**Consultation Response from KC,  
Conservation & Design**

**2025/90512 140A, Manchester Road, Longroyd Bridge, Huddersfield, HD1 3JA**

**Demolition of existing building and erection of student accommodation with ancillary spaces,  
associated garden area, store, landscaping, access and car parking**

**Date Responded: 14/5/25**

SITE PLAN Scale 1:100 0 5m 10m

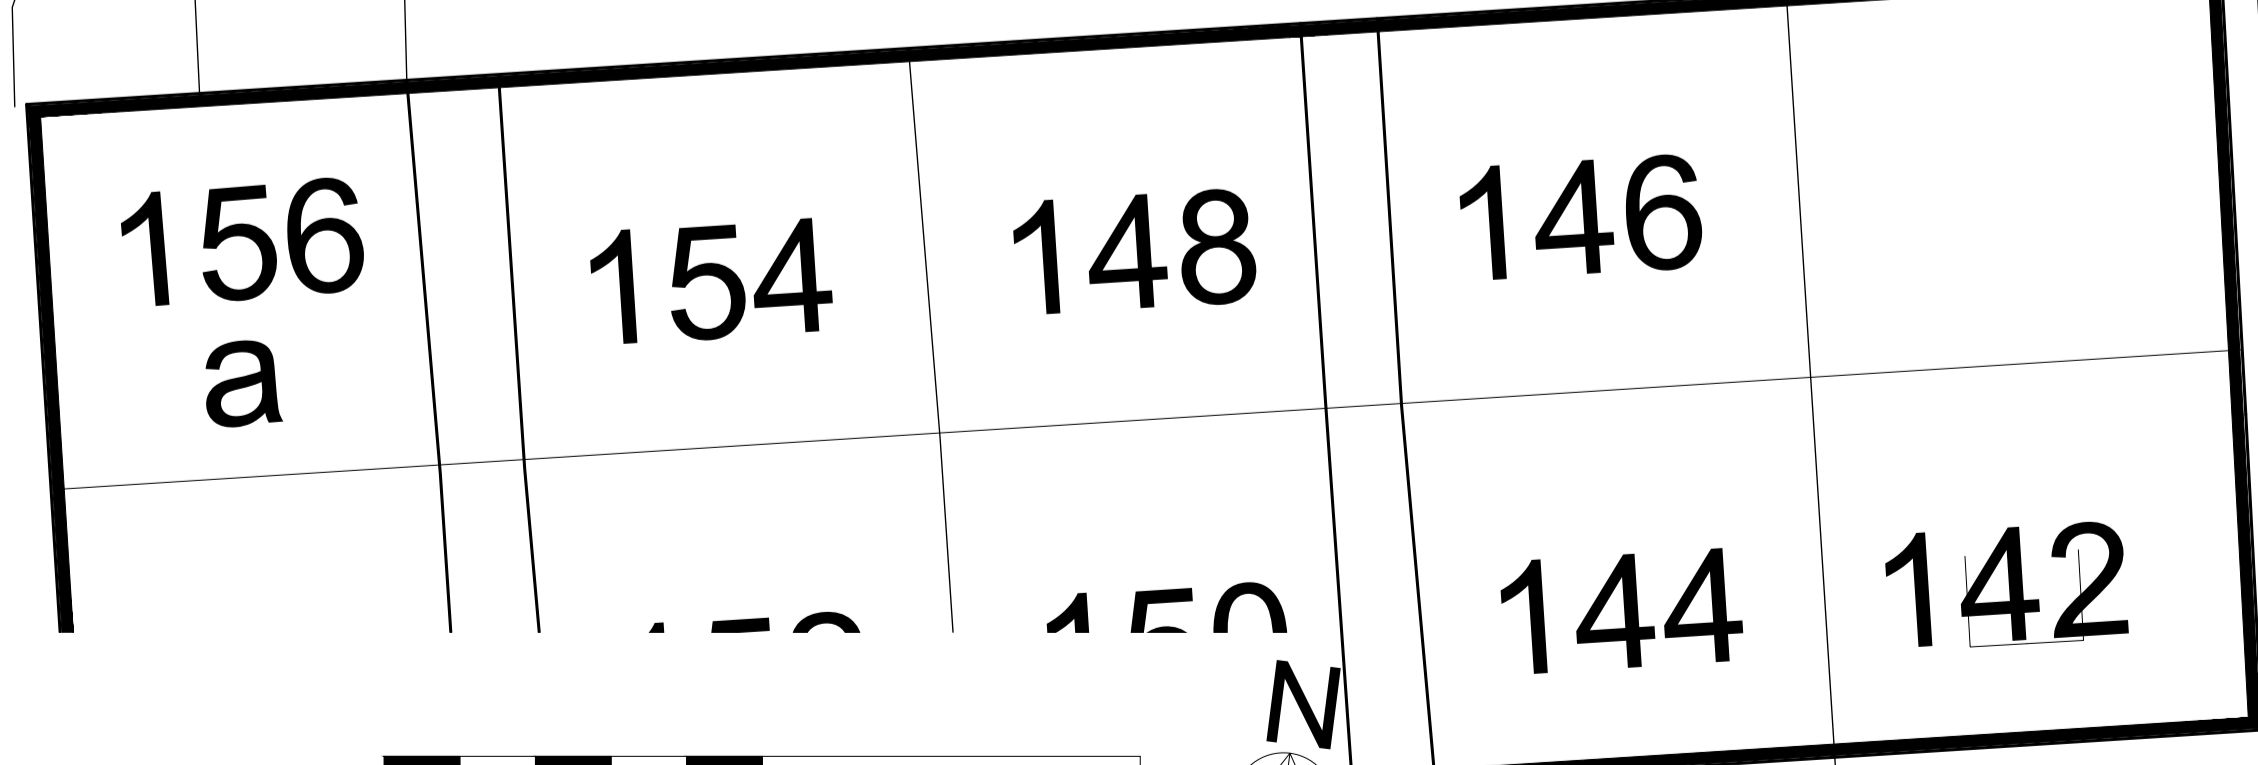
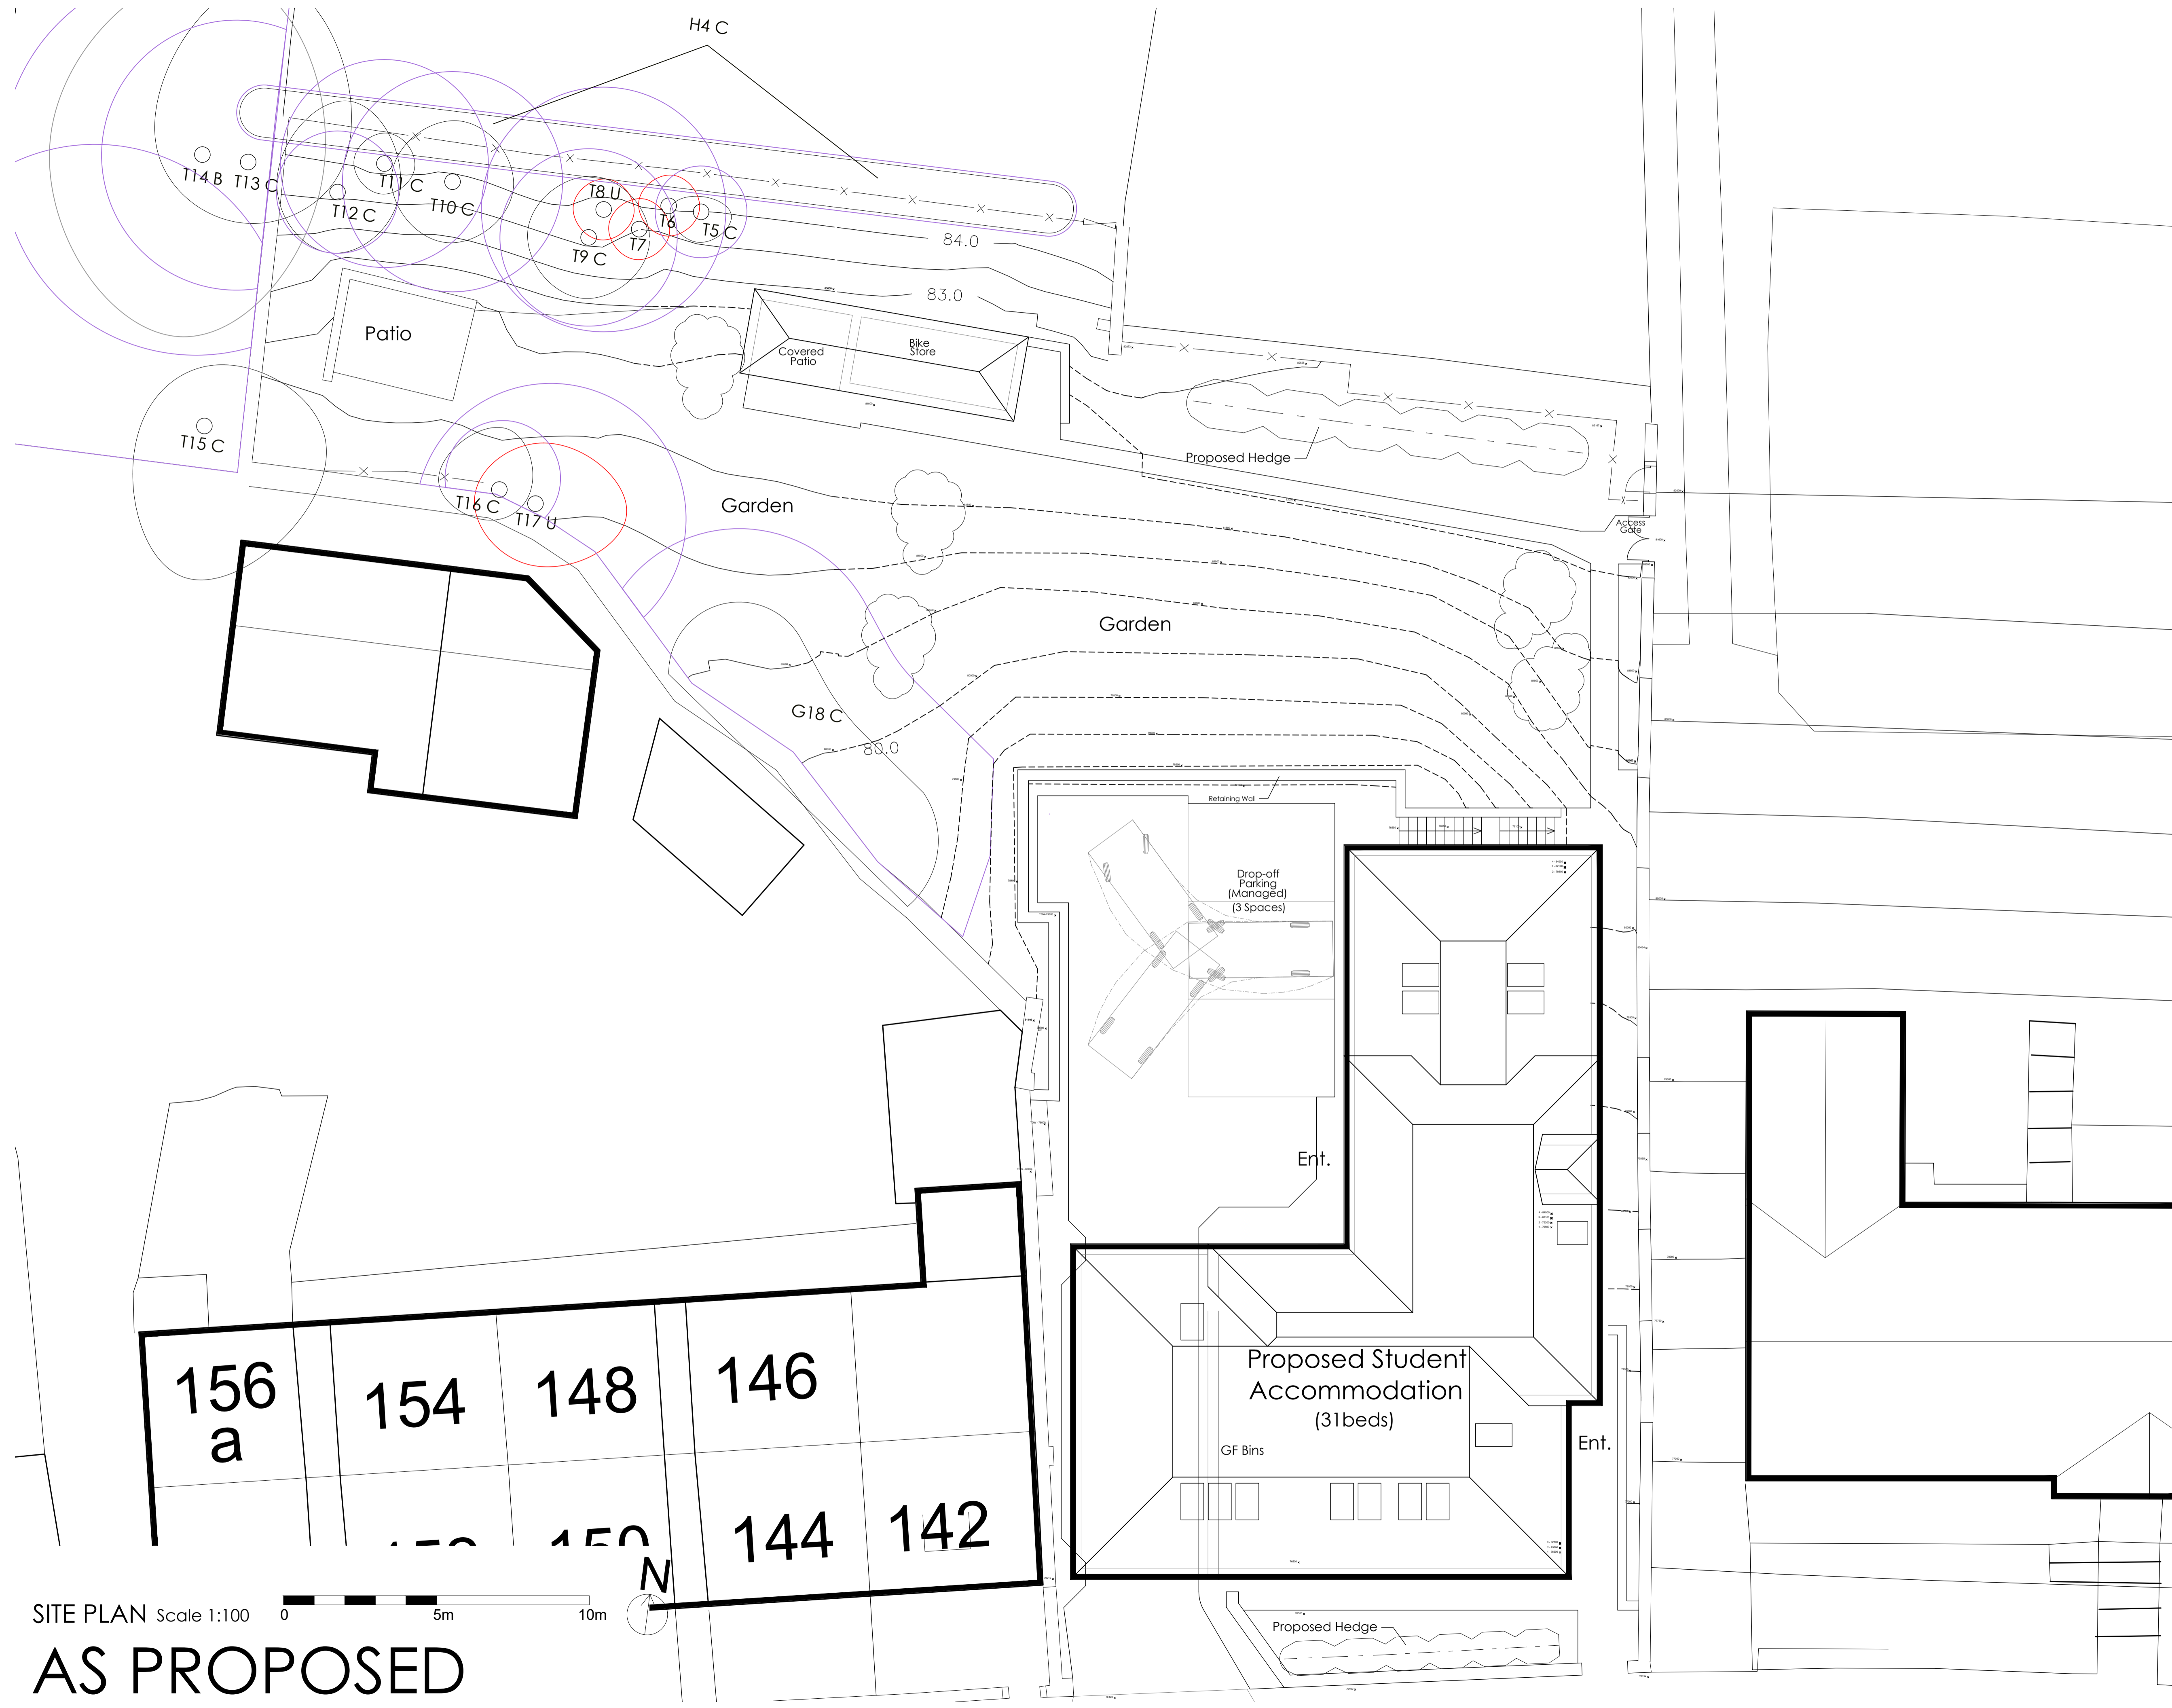
The previously proposed gates are now replaced with a new covered opening below the building which is acceptable.

The low boundary wall at the front and side should be natural stone with an appropriate coping and landscaping. Landscaping would help to enhance the setting with the listed Spring Lodge at the rear.

GA ELEVATIONS
 AS PROPOSED

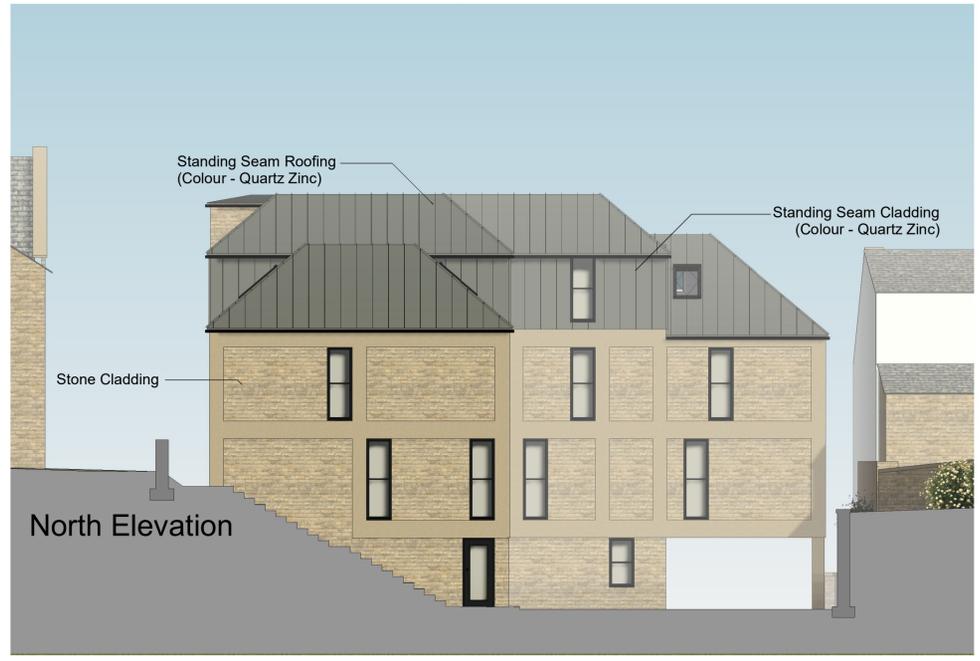
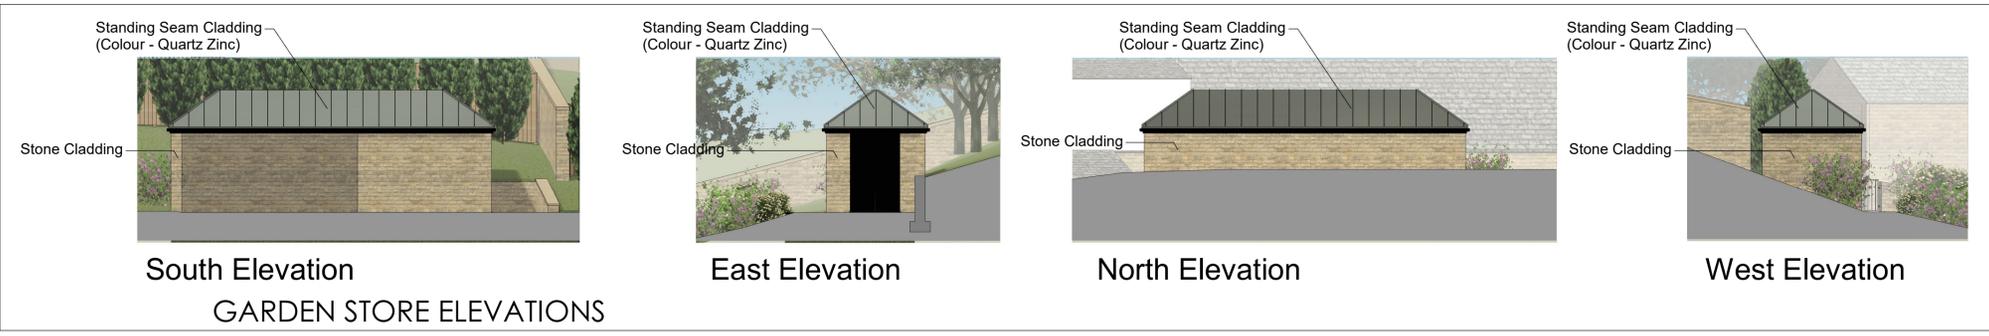
The proposed hipped roof does not reflect the properties either side which are gable roofed, but the the Spring Lodge behind has a hip with parapet, so the hip design is probably acceptable in this case.

However, the roof material proposed to be a Standing Seam roof with Quartz Zinc colour would be jarring in between other buildings with traditional slate roofs. Welsh blue slate would be a preferred material so is requested for the front block at least.

There are a large number of roof lights on the front elevation, but if blue slate is proposed, then the rooflights would be accepted.

The natural stone would be a high quality material, appropriate in the setting of other traditional buildings. The masonry materials proposed have improved by reducing the amount of metal cladding at the top floor at the rear, omission of a red brick and replacement with natural stone. The coursing and source of natural stone should match and fit in with the local buildings as closely as possible. Pointing should be flush or recessed, not strap or ribbon pointing.

Windows are proposed to be dark grey but no materials details are provided. Metal powder coated or timber windows would be preferred to uPVC in this location within the setting of the Listed Buildings. Windows and doors should be recessed by 100-150mm.

In conclusion overall the Conservation & Design Team does not object to the current proposals subject to confirmation of natural blue slate to the front block and metal/timber windows.
